## **File Note**

То:	Mr. Geoff Hynes, Inspector, Health & Safety Authority	From:	BÓC
Ref:	578-23P1222 R1	WBS:	578: 07.02.02
Subject:	Response to HSA comments on LUP assessment	Date:	27 <sup>th</sup> February 2024

This note sets out the updated response to the Health & Safety Authority's request for further clarification (as set out in An Bord Pleanála's letter of 16<sup>th</sup> January 2024) on the COMAH land use planning assessment for Tynagh North OCGT. This assessment forms part of the submission to An Bord Pleanála for the proposed strategic infrastructure development by EP Energy Development Ltd. Park North of Tynagh power station, Derryfrench, Tynagh, Loughrea, Co. Galway (ref: ABP-317810-23).

Figure 2: Wind Rose for Athenry meteorological station (2018 – 2022)

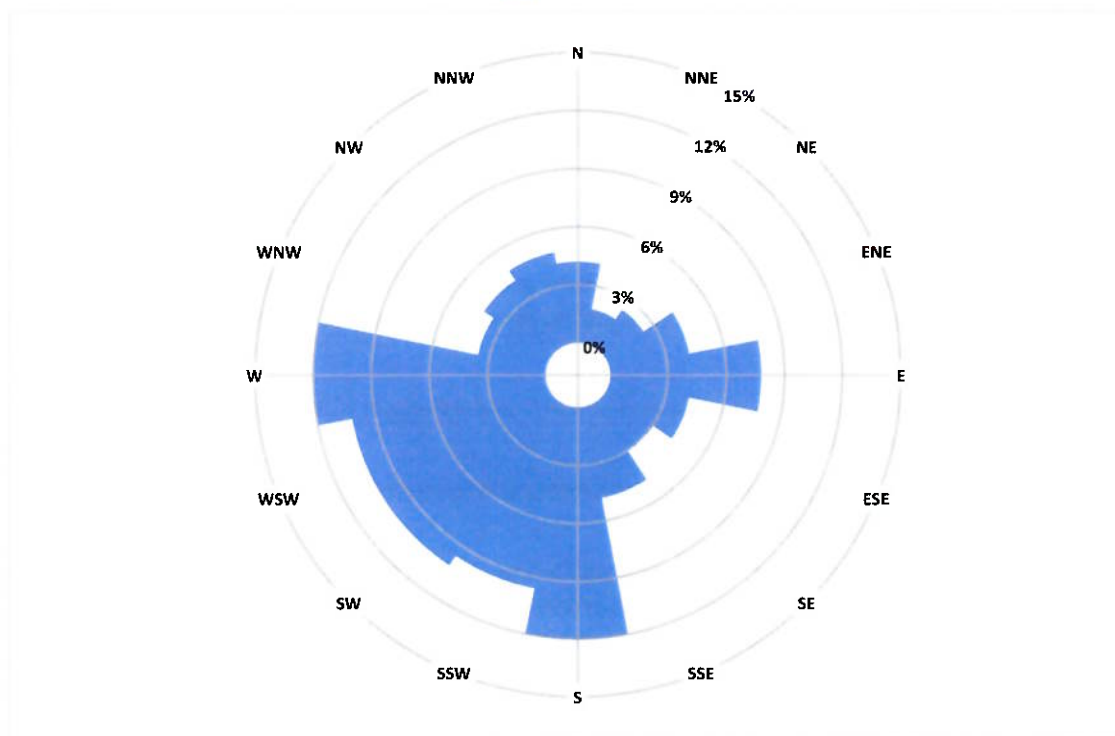
12	Section 5.2.2.2 — provide detail on meteorological data probabilities (i.e. 80/20 for D5/F2) or wind rose, which are relevant for flash fires for gas releases.	Refer to Section 5.1 of updated report.
13	Section 5.2.2.3 — provide detail on the direction used for the release for pipeline VCE hazards?	The influence of wind on the dispersal of vapour has been assessed. The meteorological data used in this assessment is set out in Section 5.1.
14	Section 5.2.3 — what approach has been taken to ignition location for gas pipeline VCE events?	The VCE consequences were estimated from the centre of the cloud using the EFFECTS model. Using the flammable cloud dimensions (from the EFFECTS model), the blast centre was placed at a variety of locations using the wind probability distribution from the wind rose model described in Section 5.1 of the updated report.
15	Section 5.3.1 Table 7 — HSA refs should be Events #123, #125, #127.	Corrected.
